Your Ref: OWPC21433
Our Ref: EP/186/18/HH 21-12-2018
Please ask for:
Zac Denton

Two storey side extension, rear extension and front extension including demolition of existing conservatory and alterations to fenestration

1 Tamarisk Way East Preston

Thank you for your internet representation made on 12th February 2019 which has been recorded as '**an objection**' with the comments as follows:

Proposed First Floor Plan 1:50

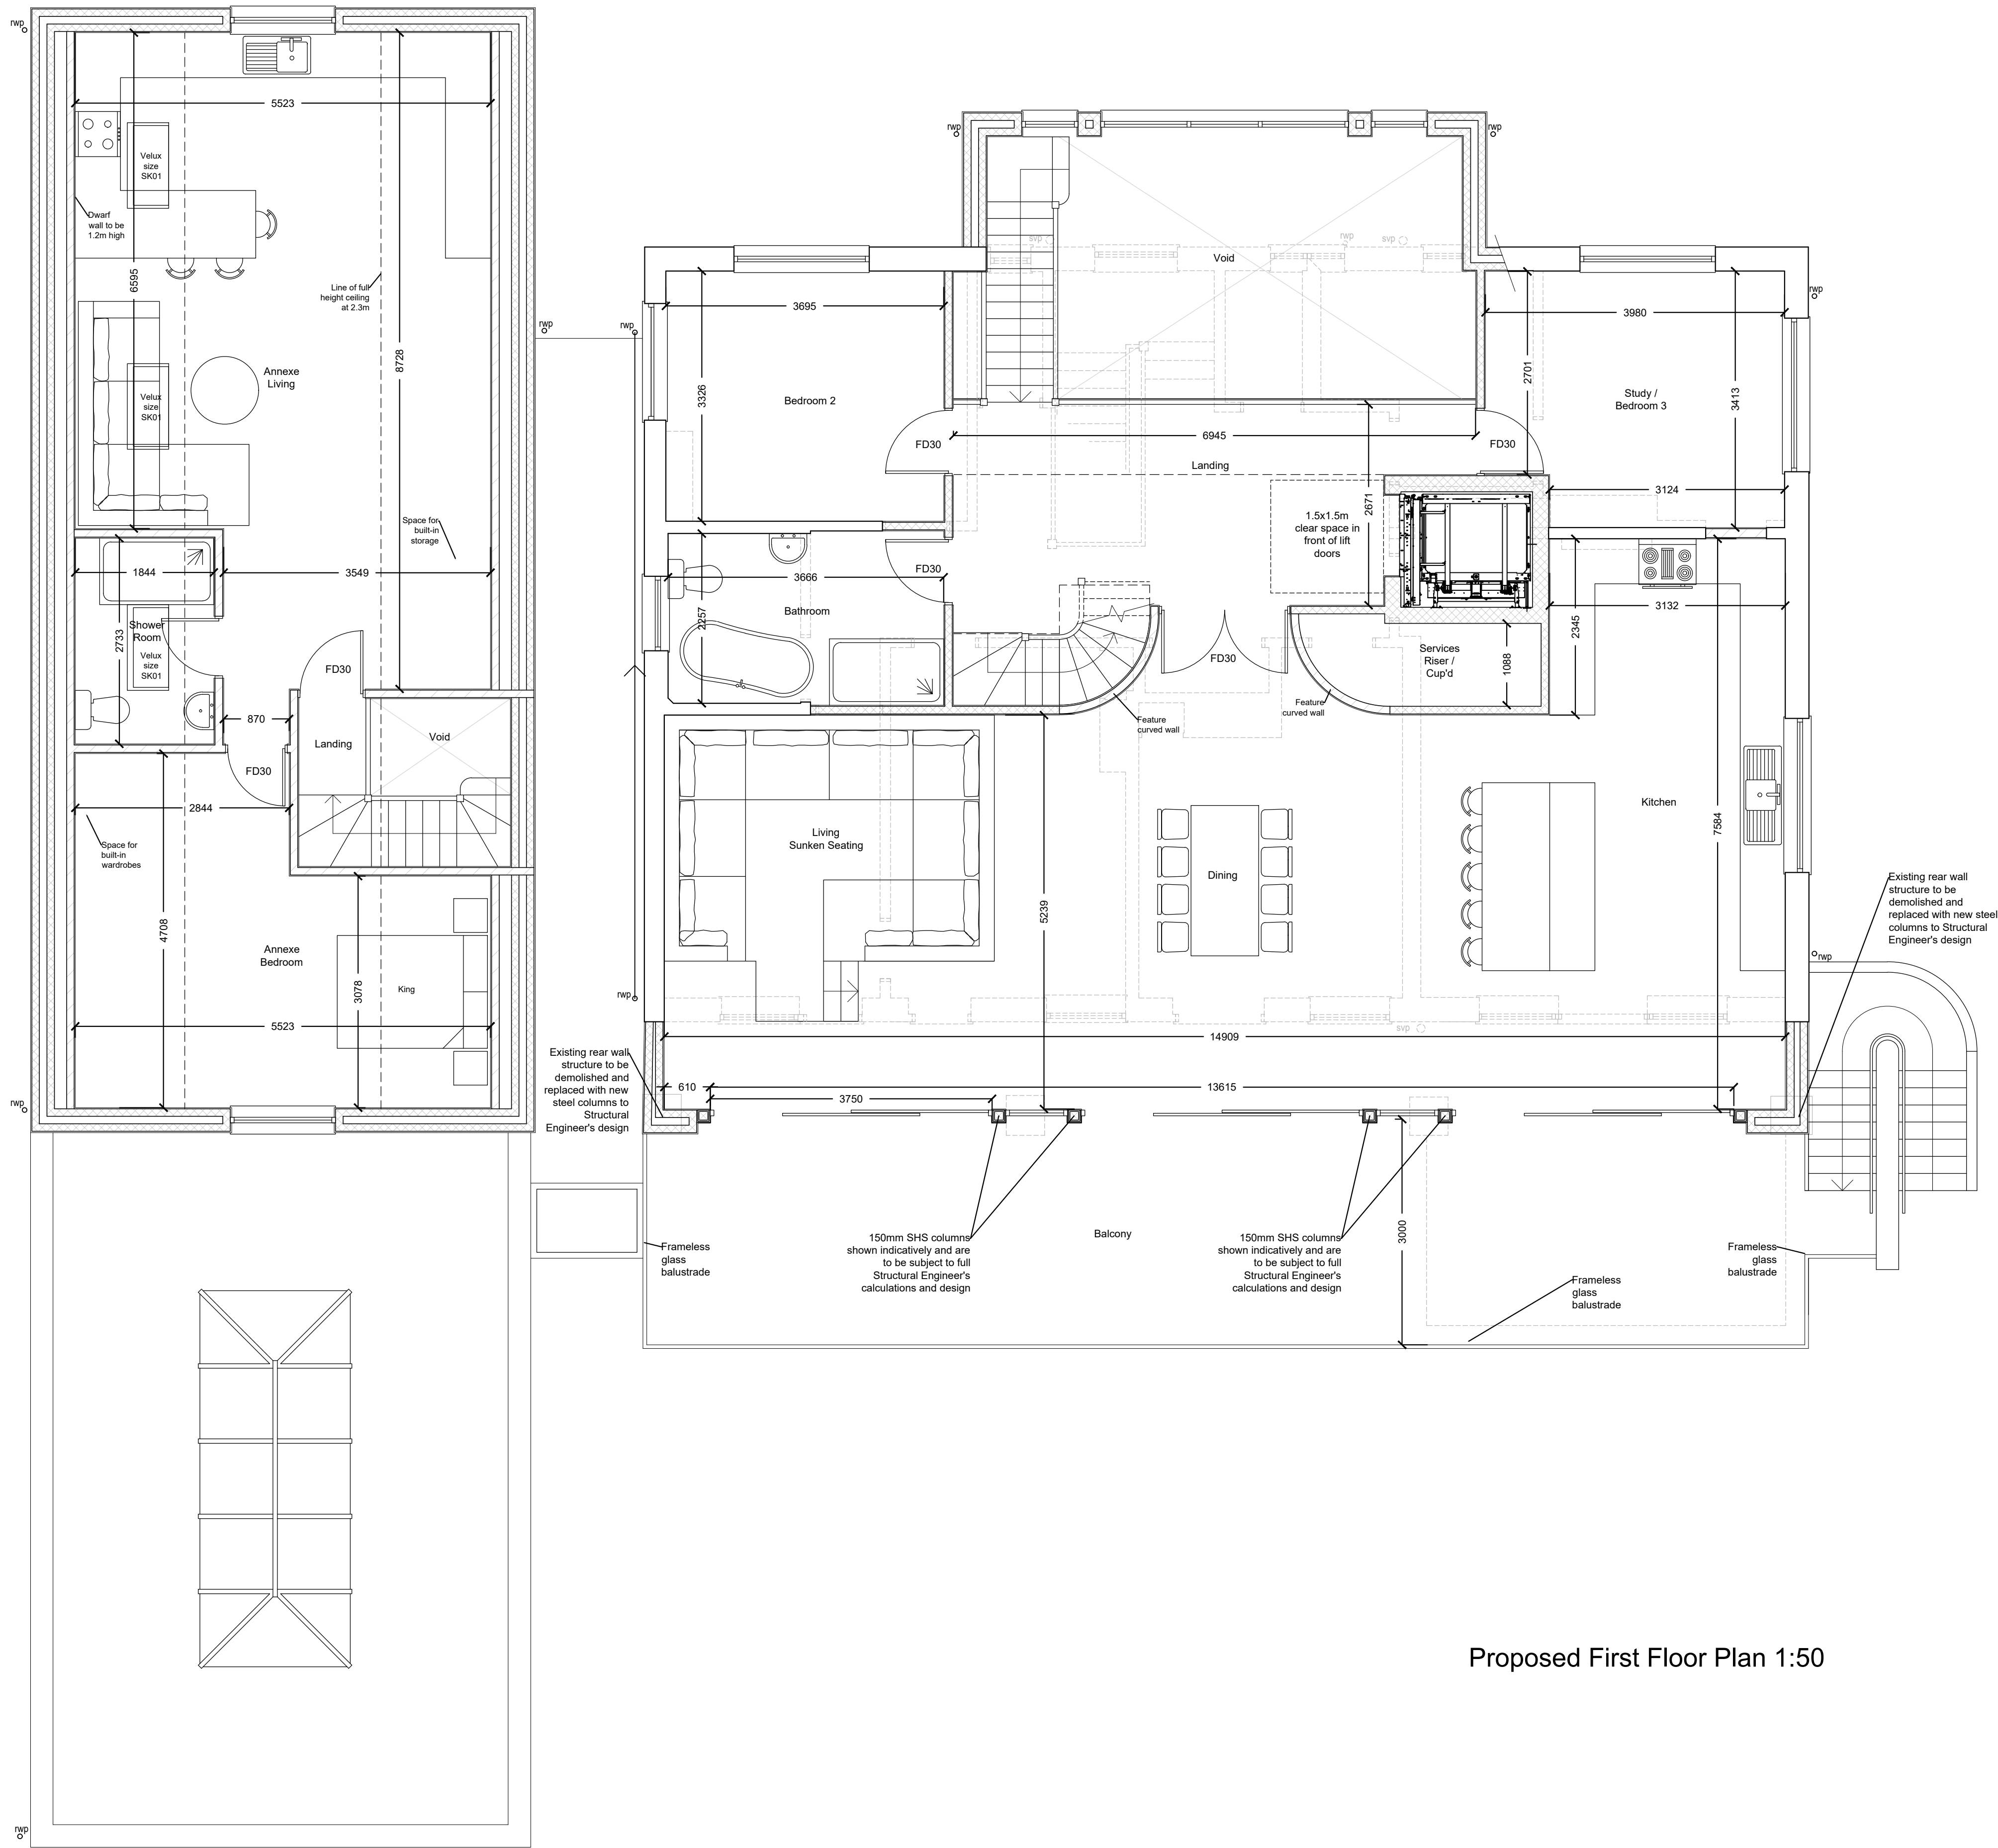
I wish to object the balcony on both the 1st & 2nd floors as this would overlook both 3 Tamarisk Way and adjoining Seafield Road rear gardens as this would be an intrusion upon their neighbours privacy.

The proposed balcony on the first floor would be extensive and could accommodate a number of people and potential noise from that area would not only be an annoyance to their neighbours, but would cause disturbance and take away pleasure to people walking along the Greenward.

DRAWING TITLE
Proposed Second Floor Plan &
Elevations
PLANNING ISSUE

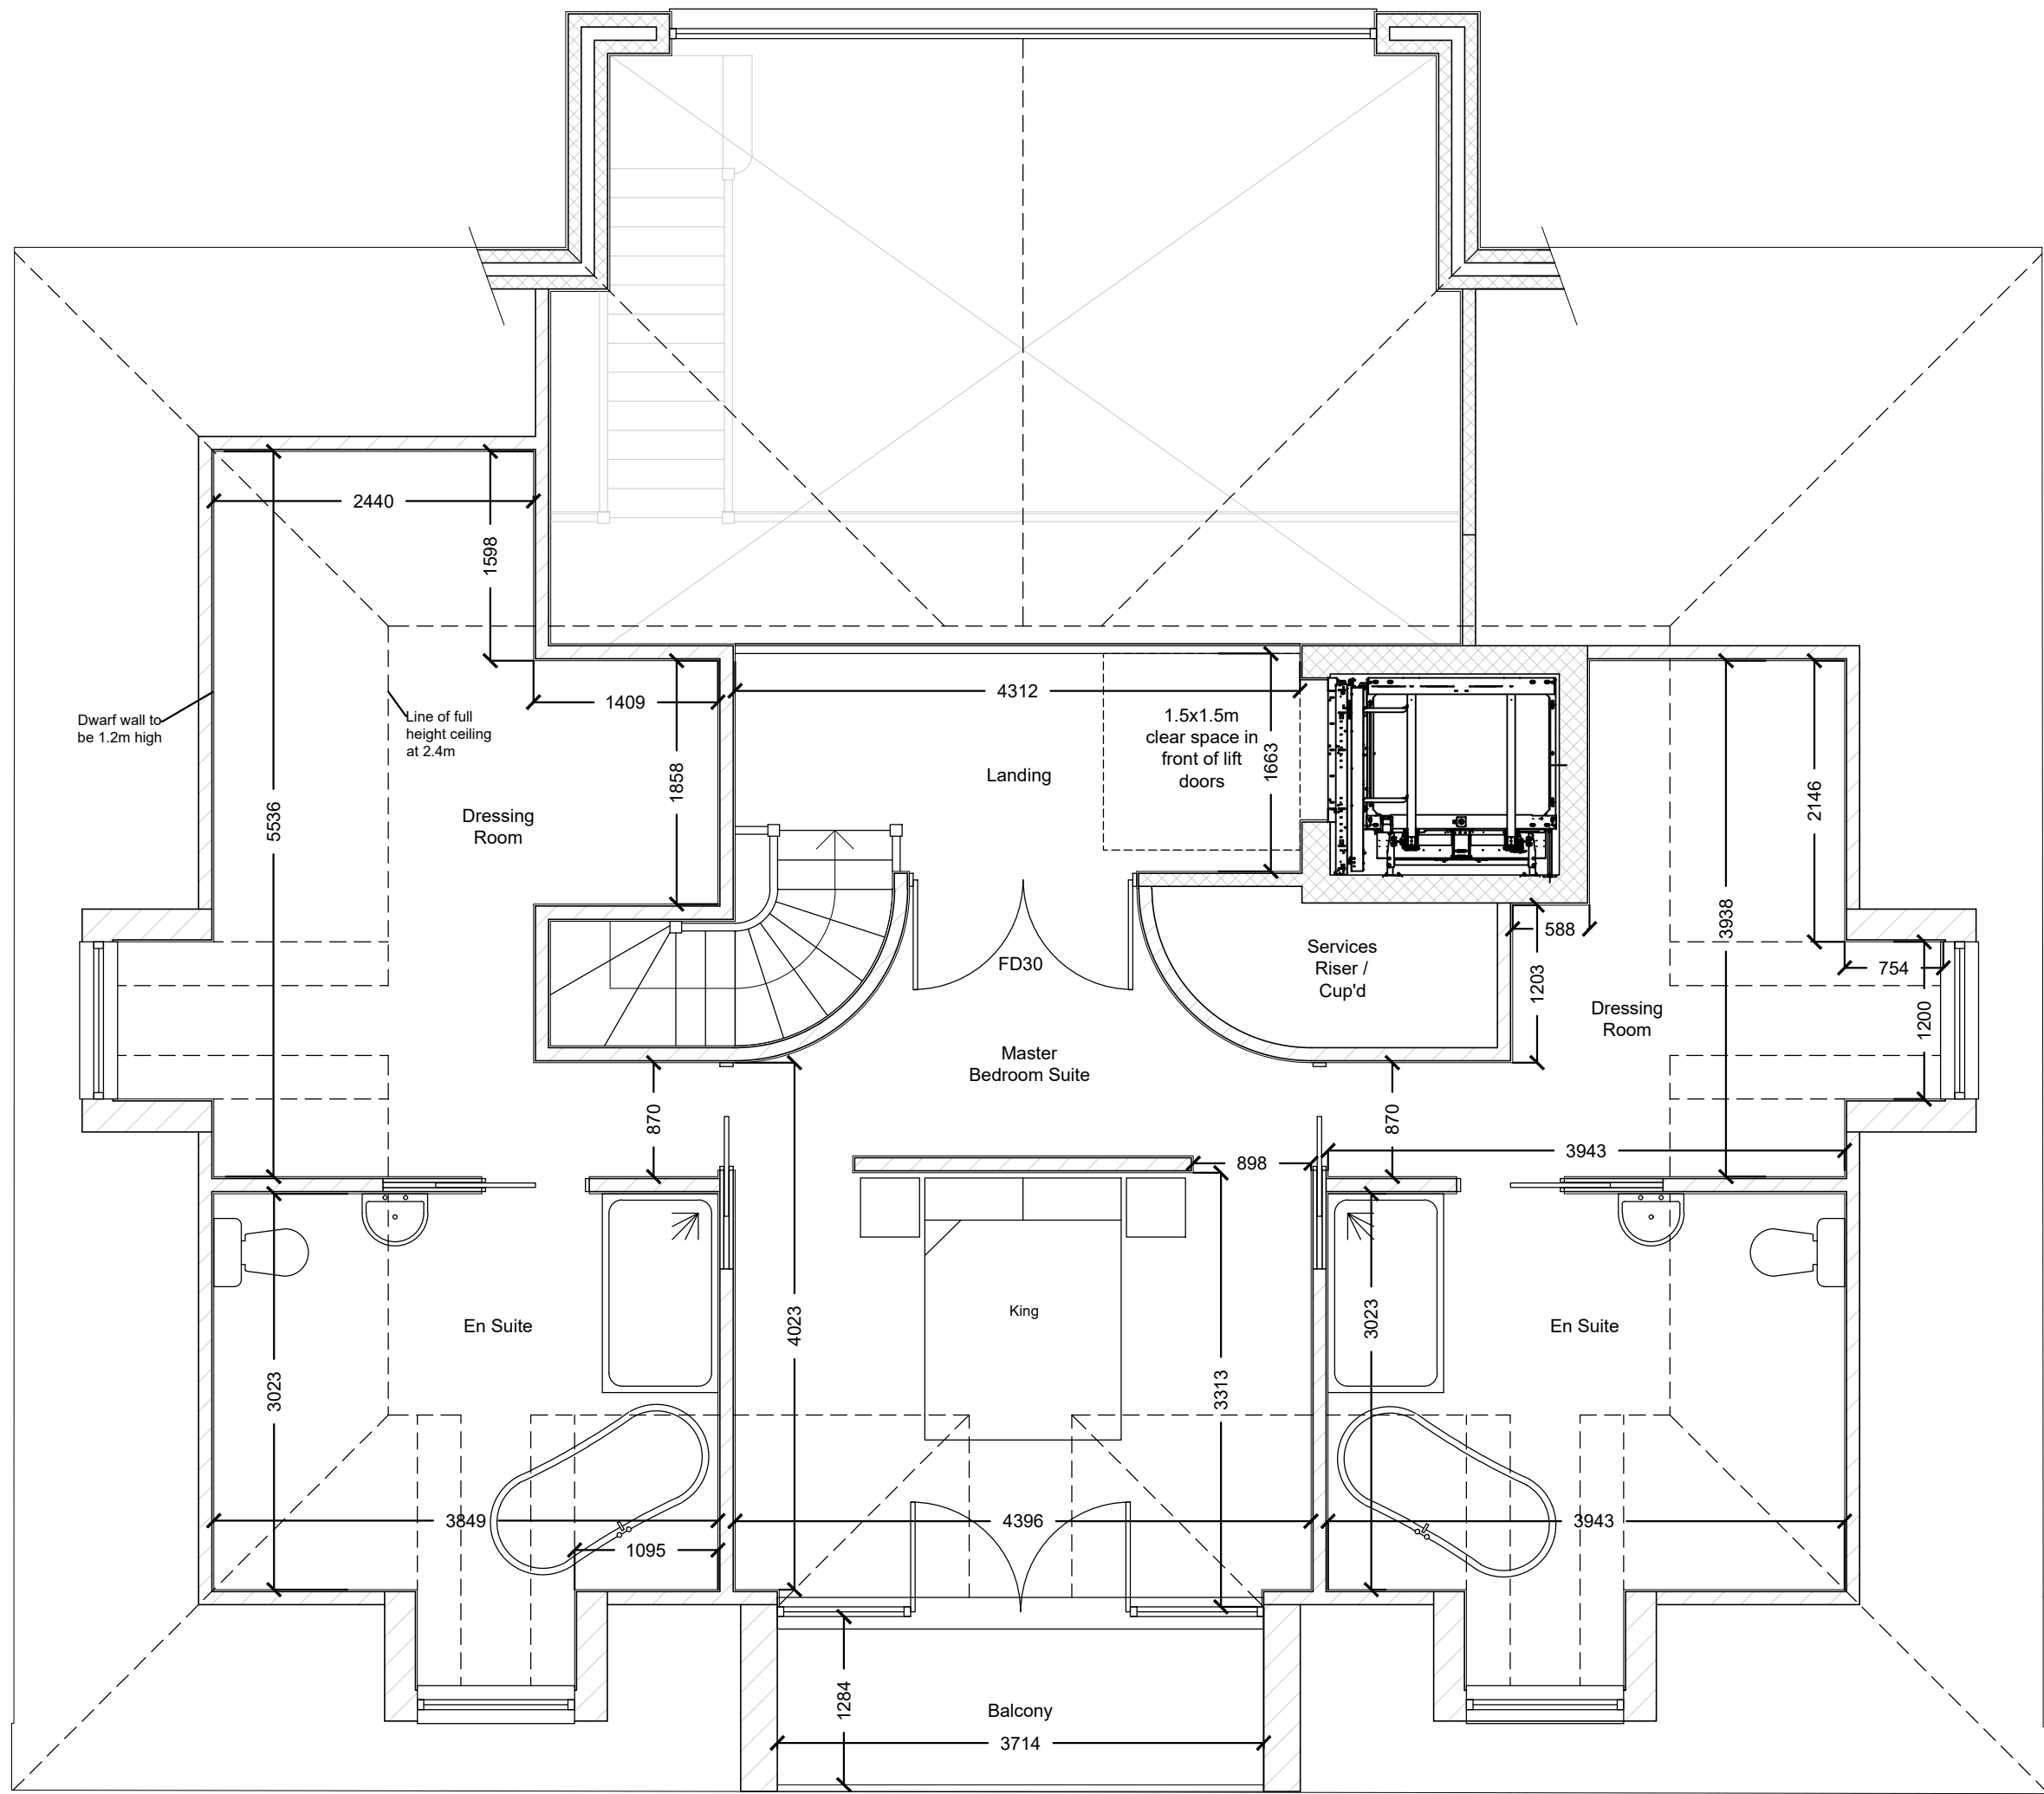
I would also wish to object to the large glass doors instead of the much smaller window that currently exists on the second floor level.
